# CITY OF ALBUQUERQUE

April 18, 2022

**Re: Pima Medical Institute New Class Room Building**  
**4400 Culter Ave NE**  
**Traffic Circulation Layout**  
Architect's Stamp NO date provided (H17-D054B)

TCL001

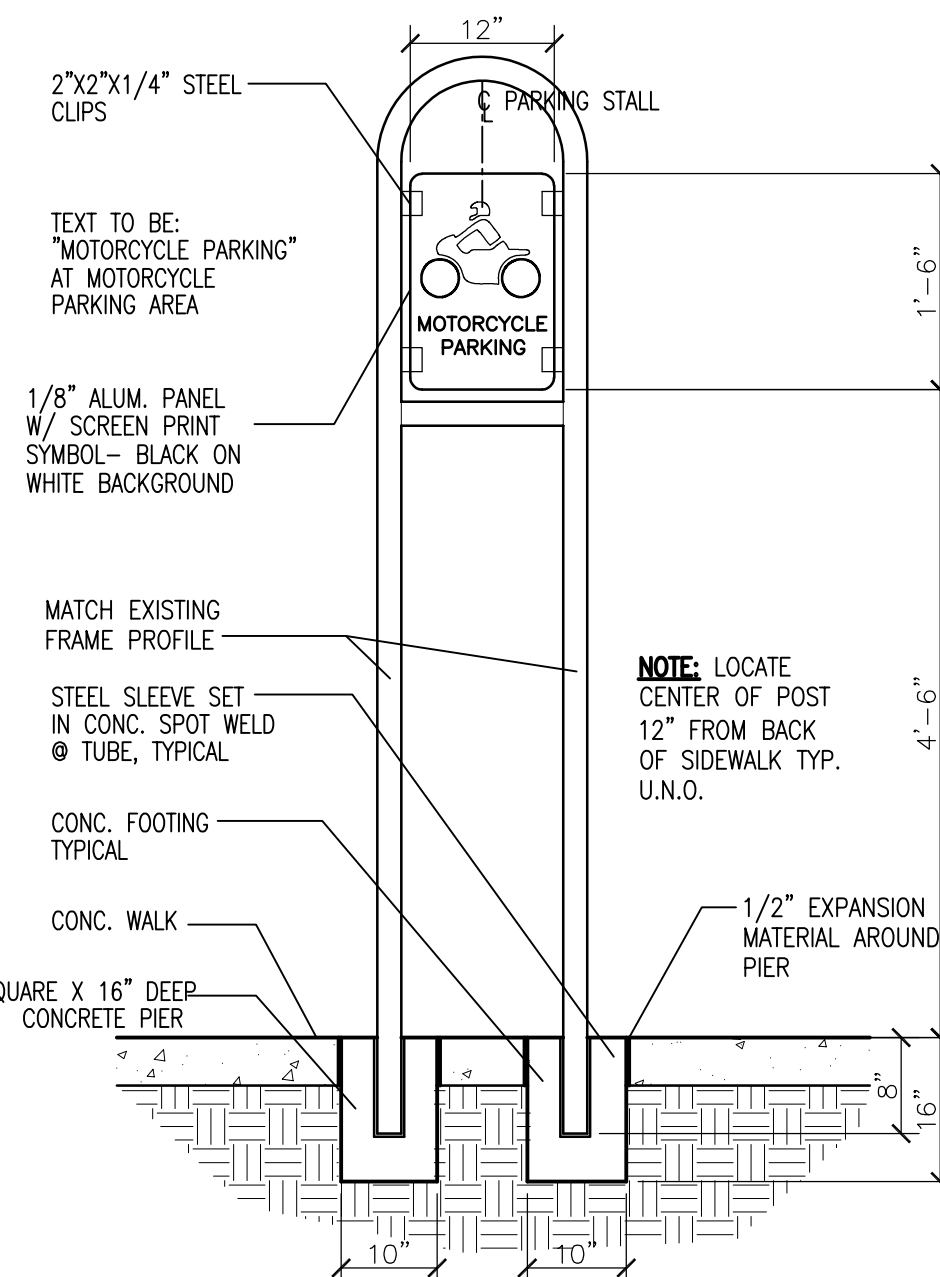
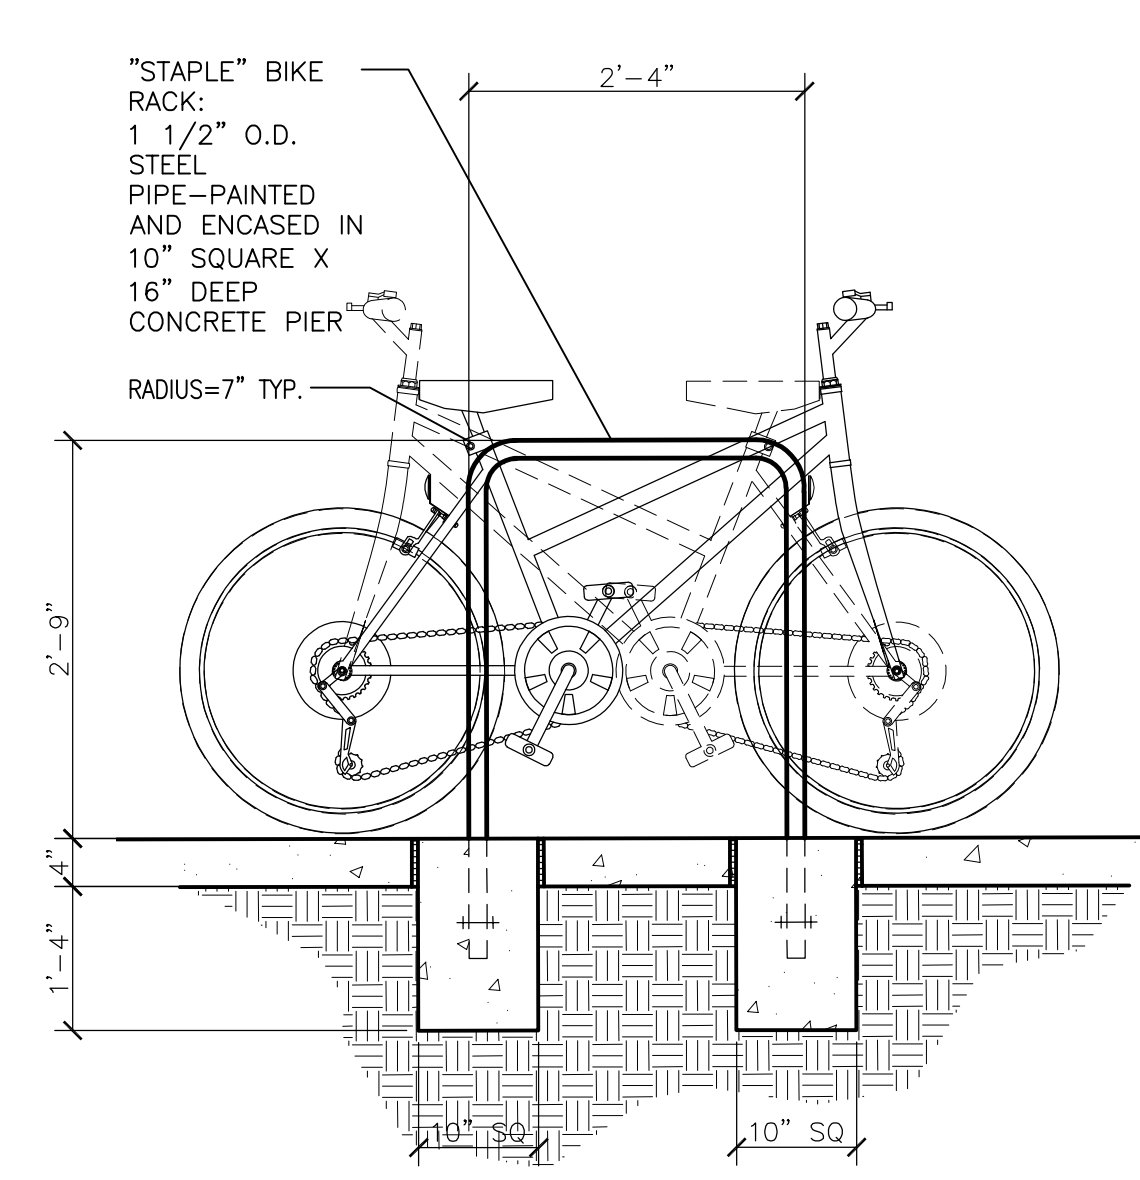
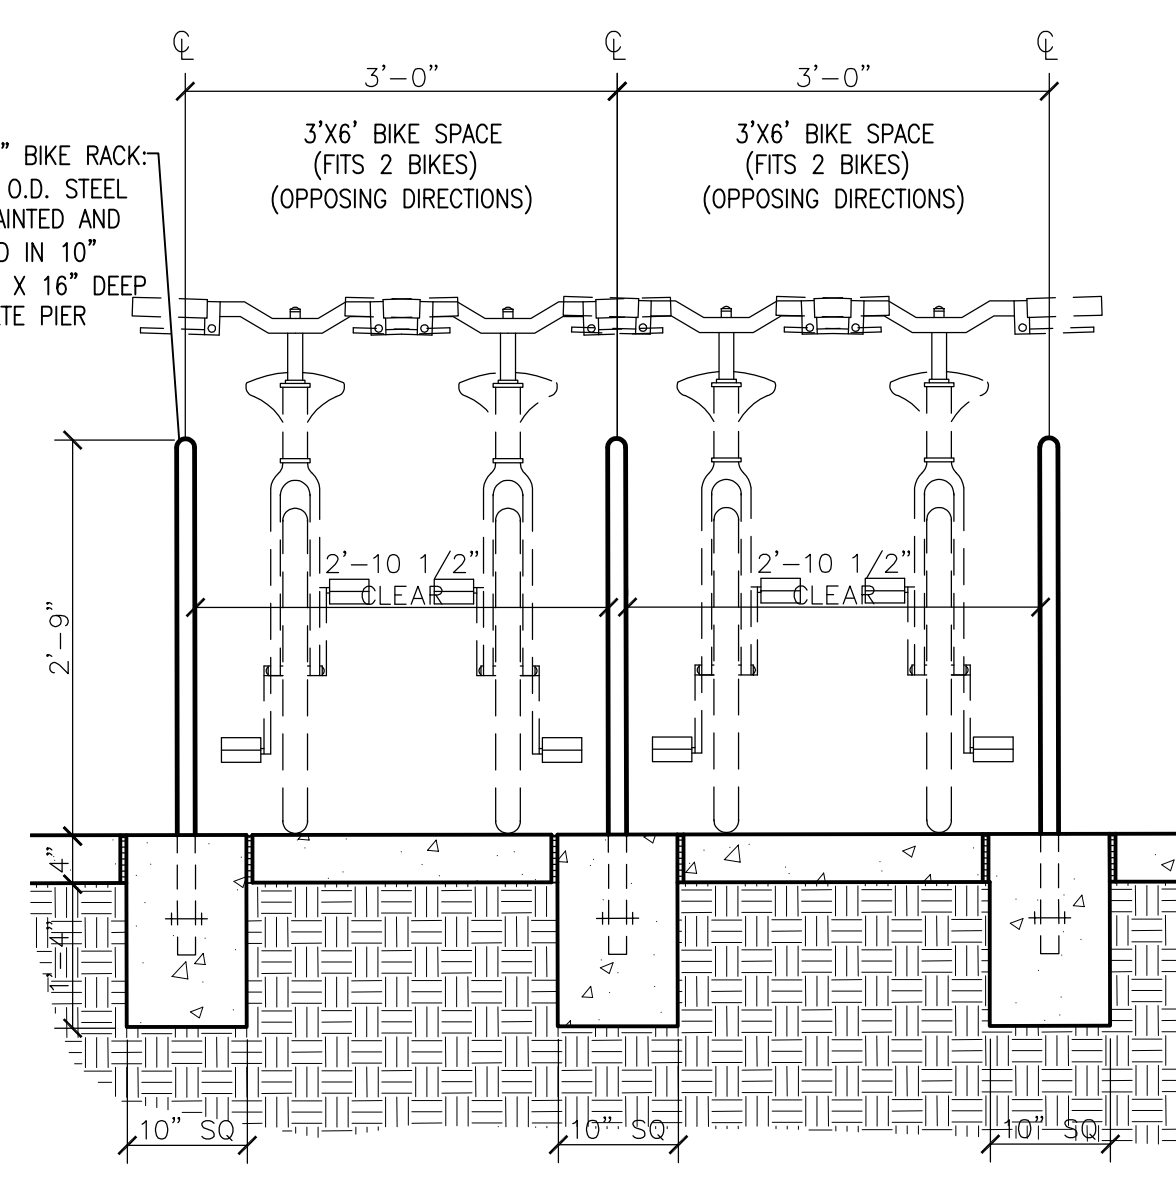
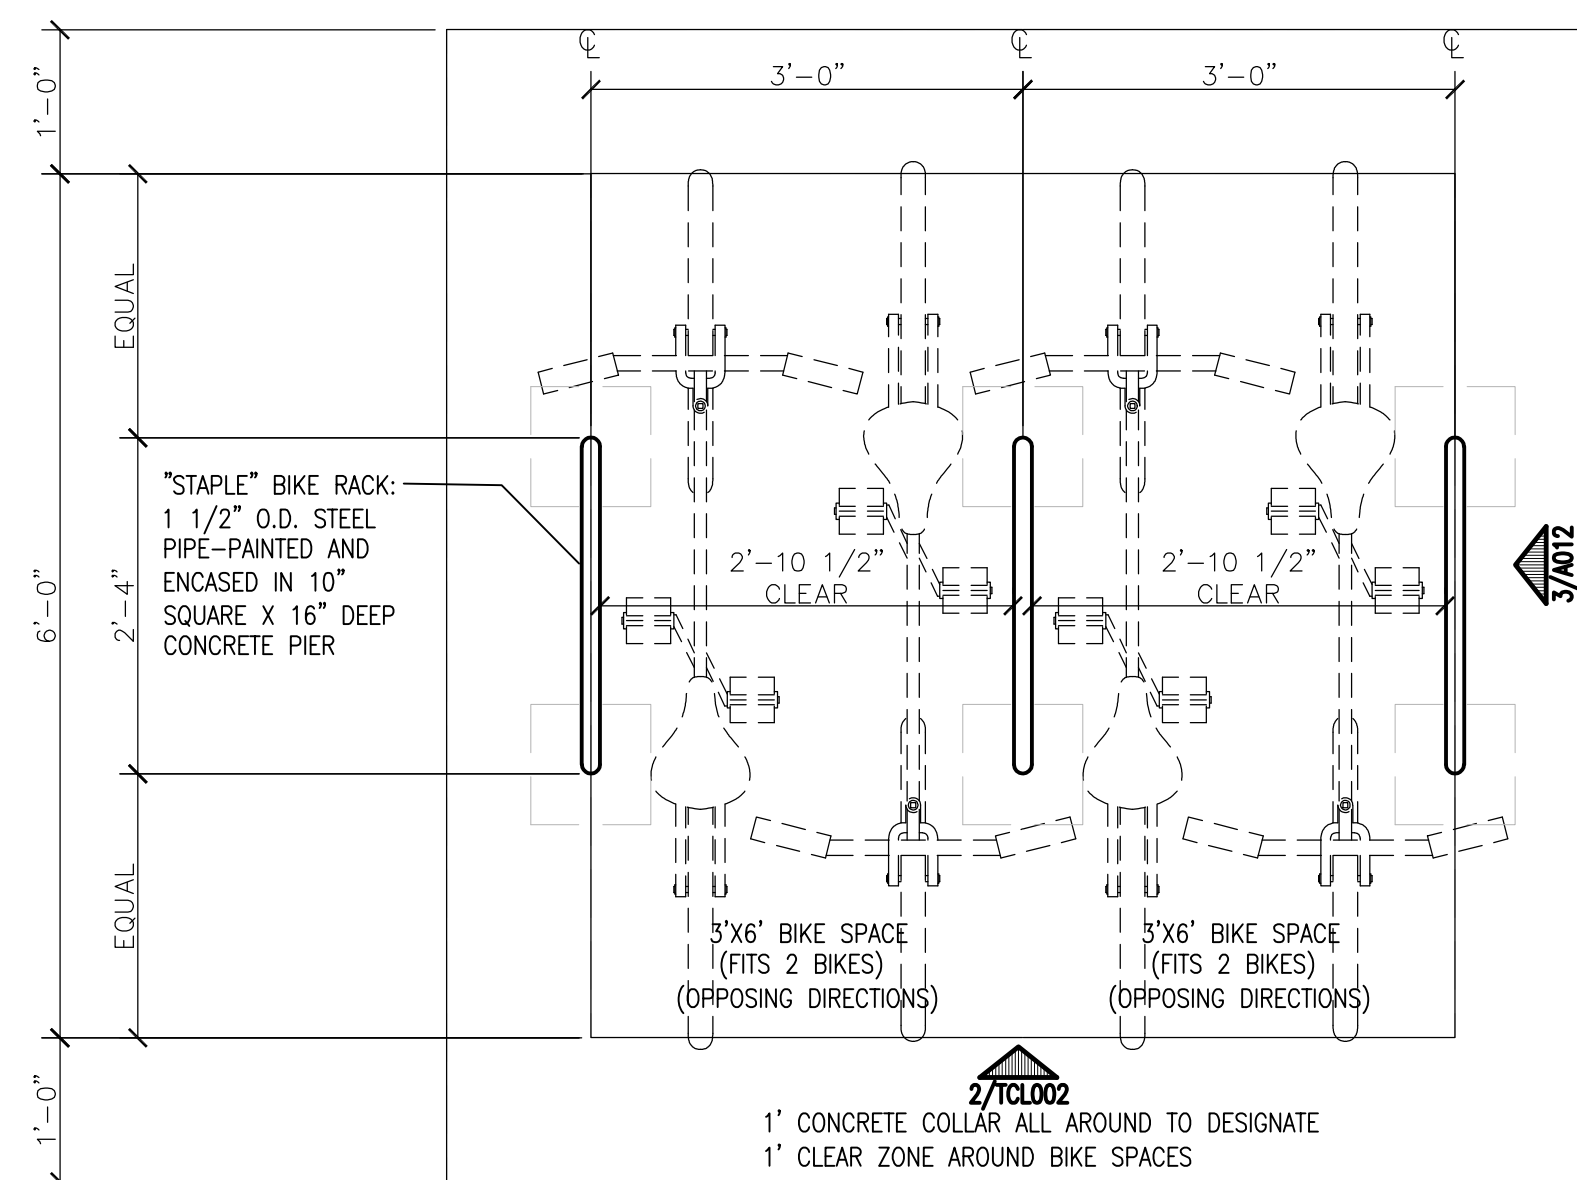
- The current ramp run (12:10) connection onto the sidewalk connection is not ADA accessible.
  - Per the DPM, a 6 ft. wide ADA accessible pedestrian pathway is required from the public sidewalk to the building entrances. Please clearly show this pathway and provide details and demo any existing/old sidewalk connection that doesn't meet the requirements above. Make sure you provide striping for this 6ft pathway across the drive aisle.

- **You will need a Sidewalk Easement for existing sidewalk located outside of public ROW. See attachment for the forms.**
3. **Handrail detail:**
  - Dimension all pathway widths on the proposed run/tapers and landings (including bottom, middle and top). Label all landings 48:1 **MAX** and all runs/tapers 12:1 **MAX**.
